Planning Application Ref: A/70/18/DOC (2nd inspection)

Location: Quiet Waters, Roundstone Lane, Angmering

Description of works: Application for approval of details reserved by condition imposed under planning permission A/132/17/OUT relating to condition No. 17 (Tree scheme of protection) & 22 (Contamination risks)

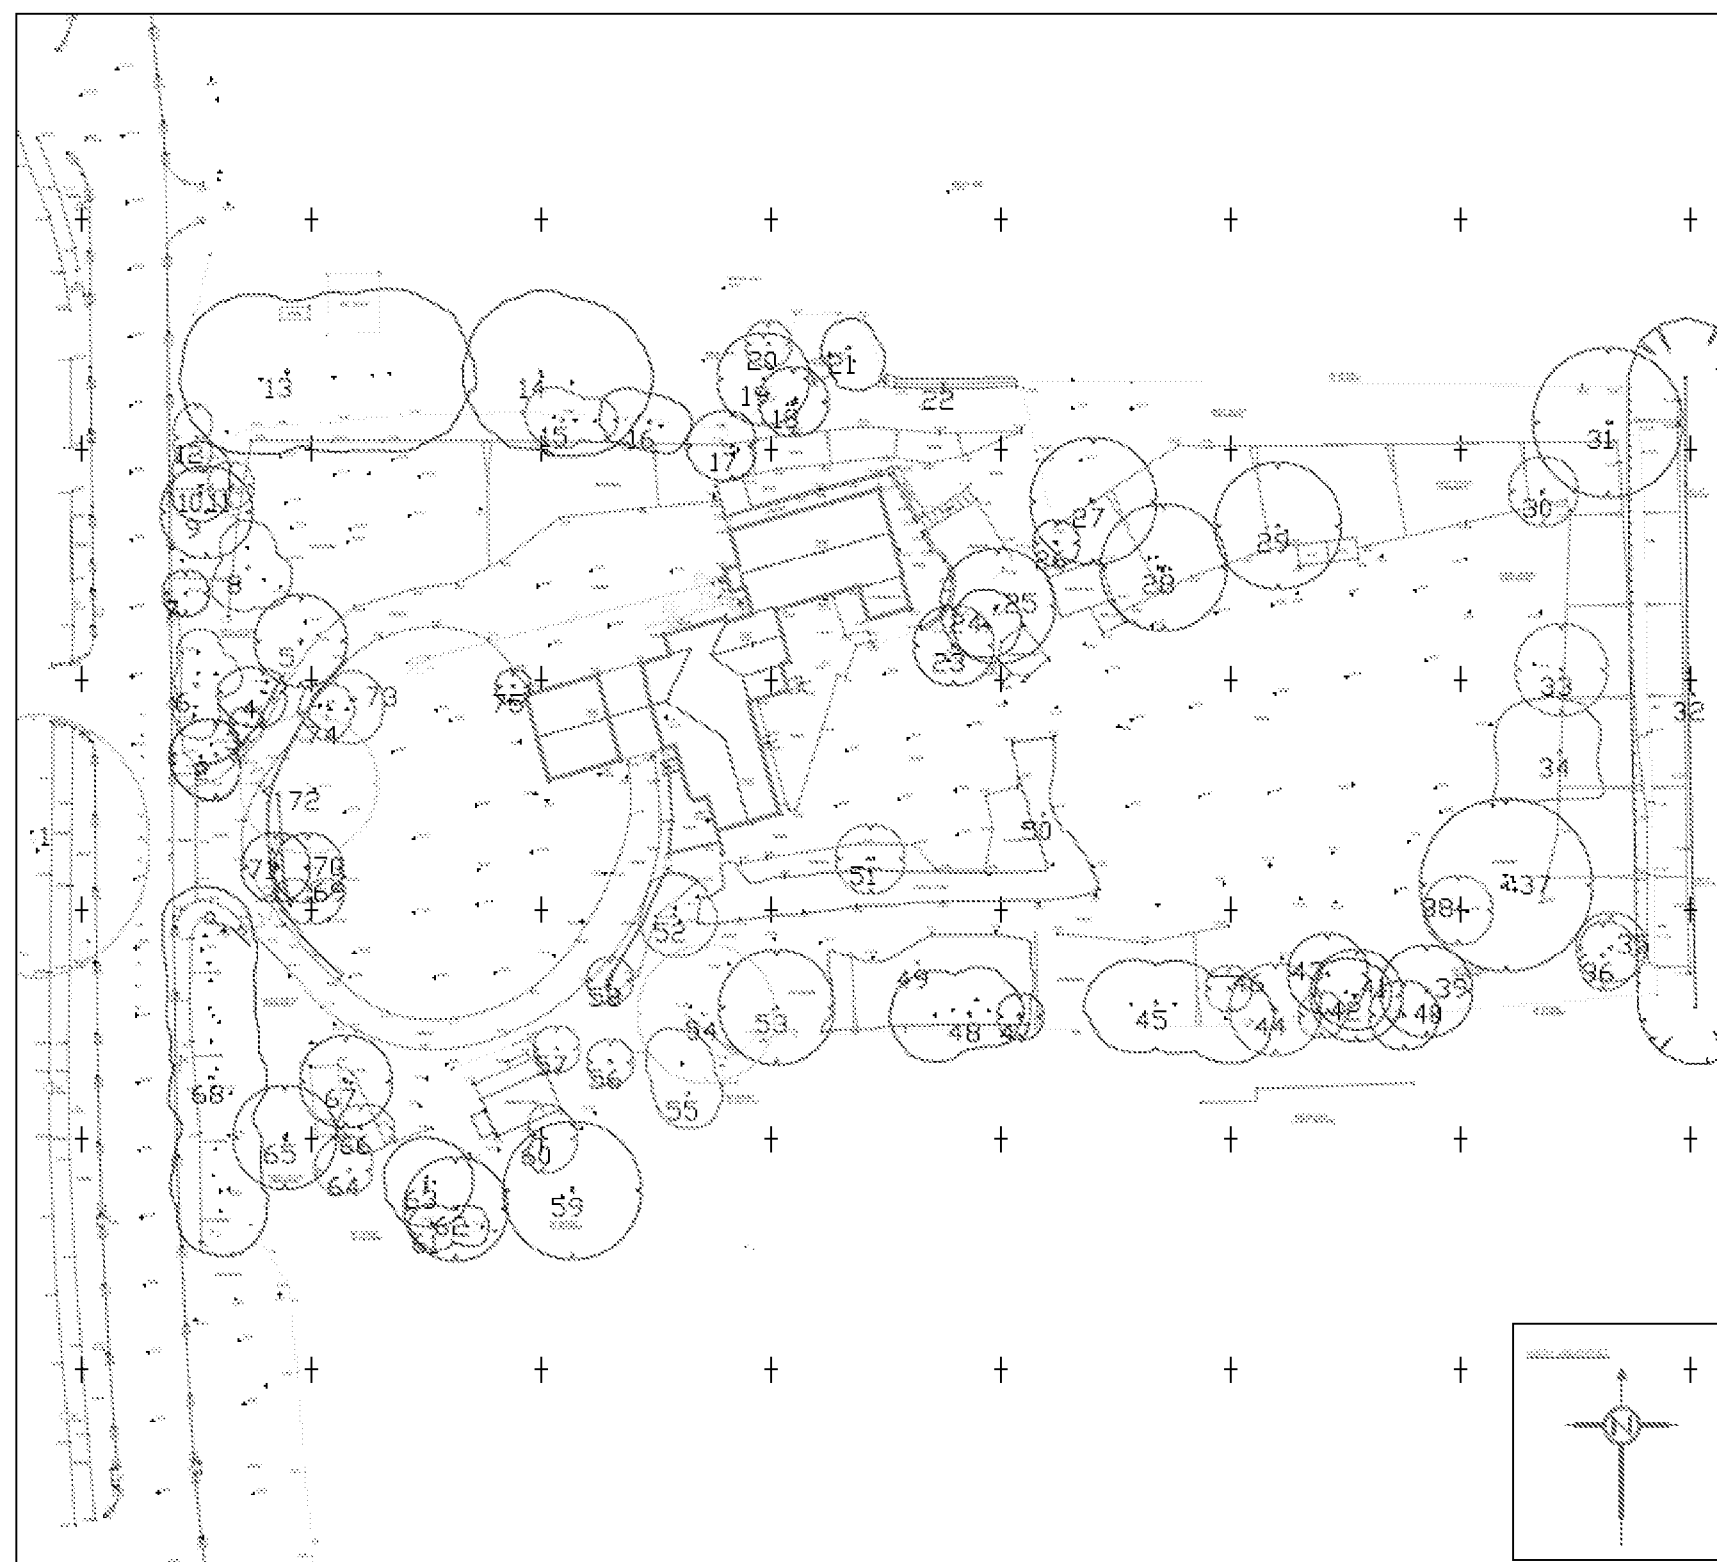
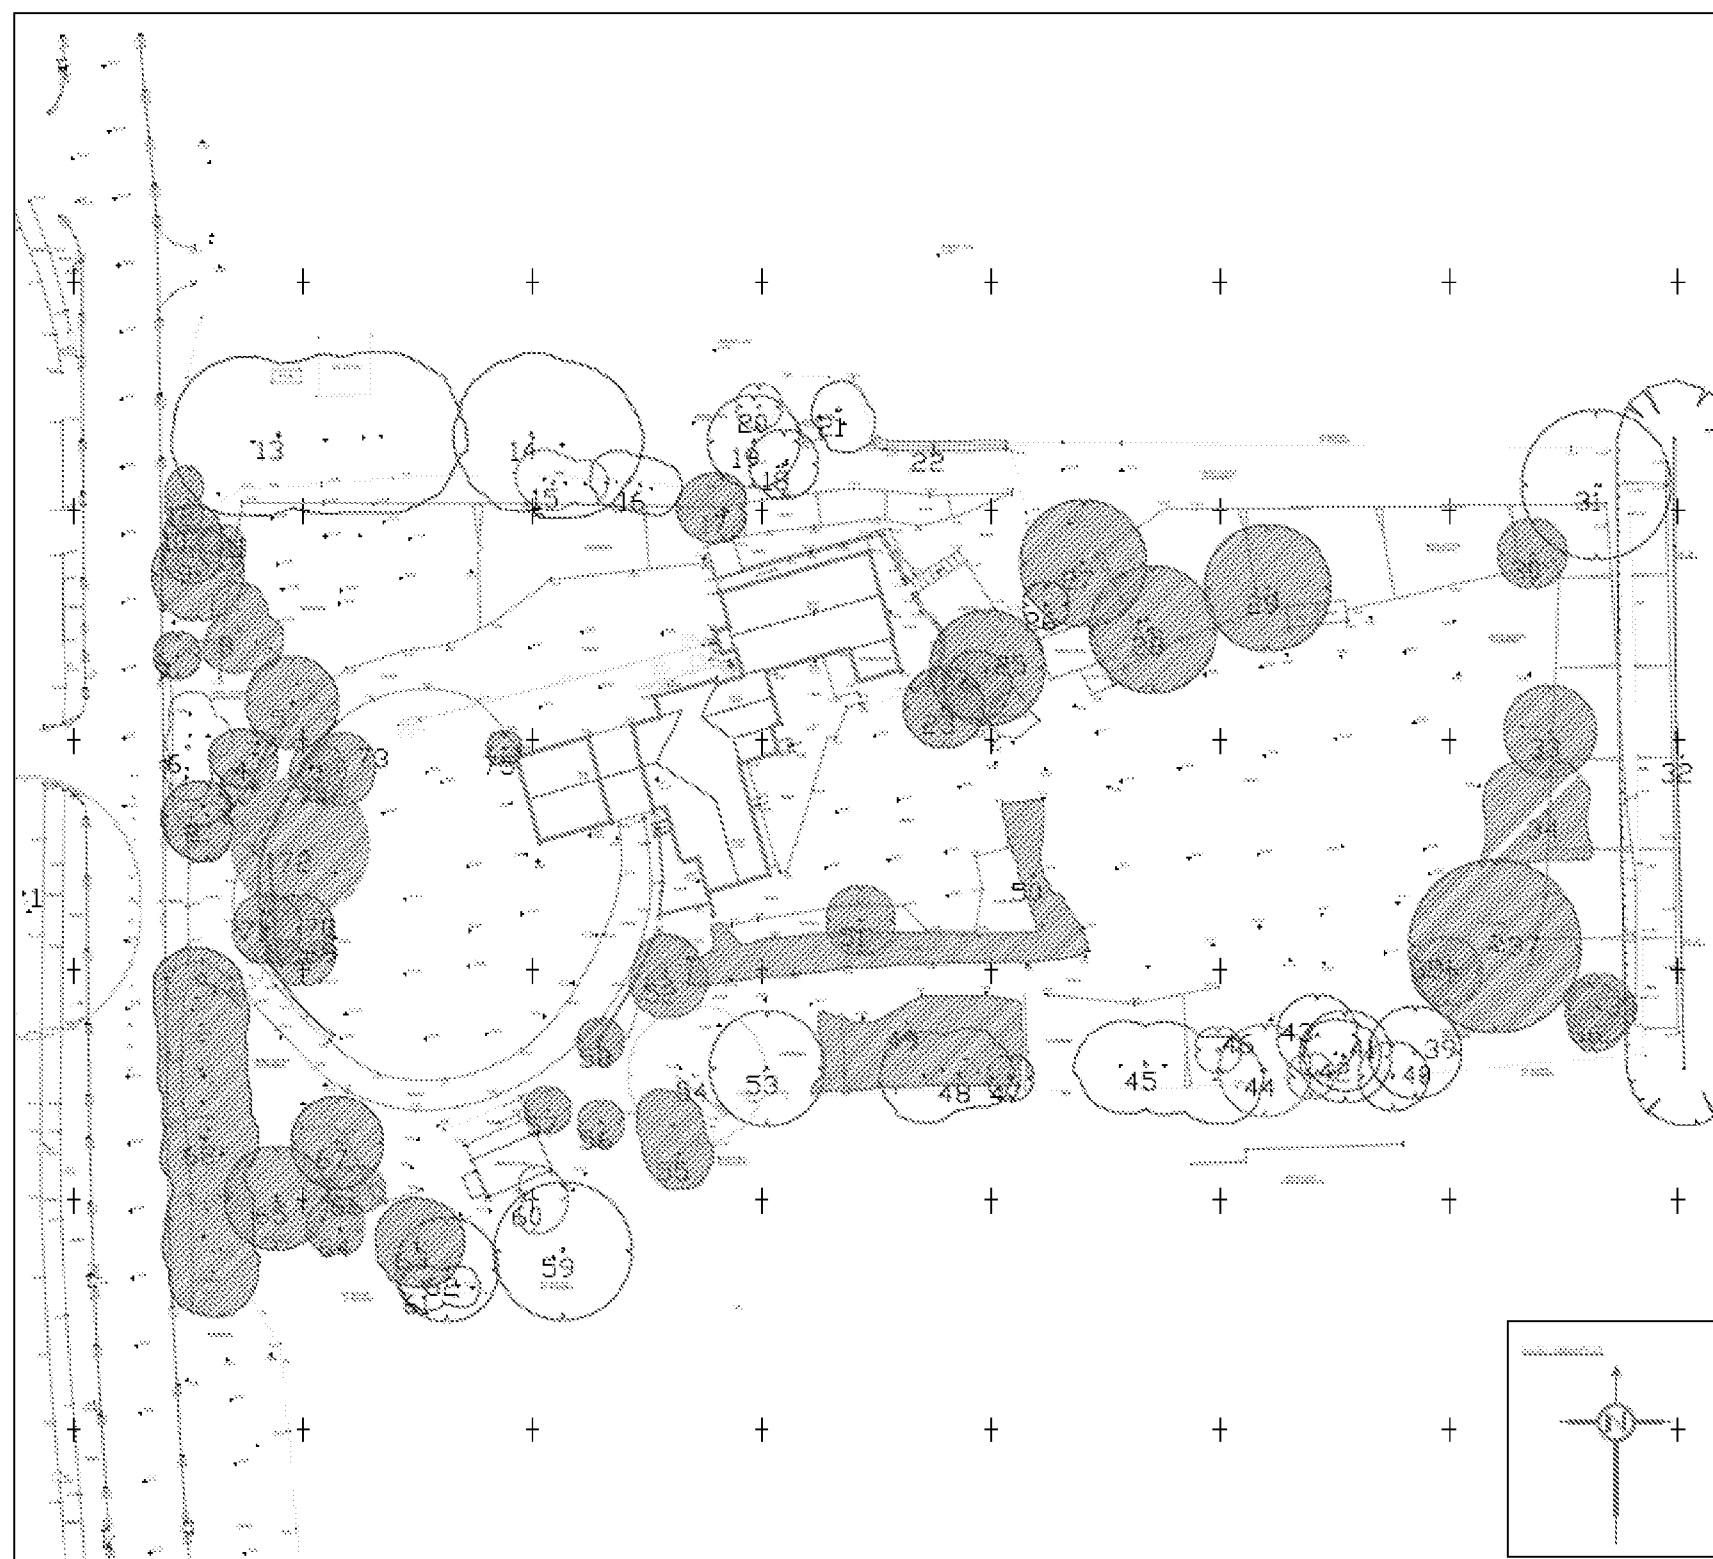
- Drawing No. NJCL 252 C, dated 21.05.2018, from Nicholas Jones Consultants Ltd., submitted in support of A/81/18/RES
- All Tree Protection Fencing had been erected. A number of panels were insufficiently stabilised without back-stays and sat in block trays rather than pegged securely into the ground. Fencing was incorrectly positioned in relation to the Root Protection Area of TPO trees (T53 & T54). Measurements were taken and the correct position identified.

- Mr Ashworth was able to resolve the above issues later that day and I was able to return to site early afternoon to confirm the same.
- The abrupt changes in ground level across the site have made a neat installation difficult to achieve in some areas, notably so on the sites North and East boundaries. They are effective nonetheless and I am reassured by Mr Ashworth's plan to enhance their integrity as work progresses, including the installation of securely pegged back-stays at regular intervals.
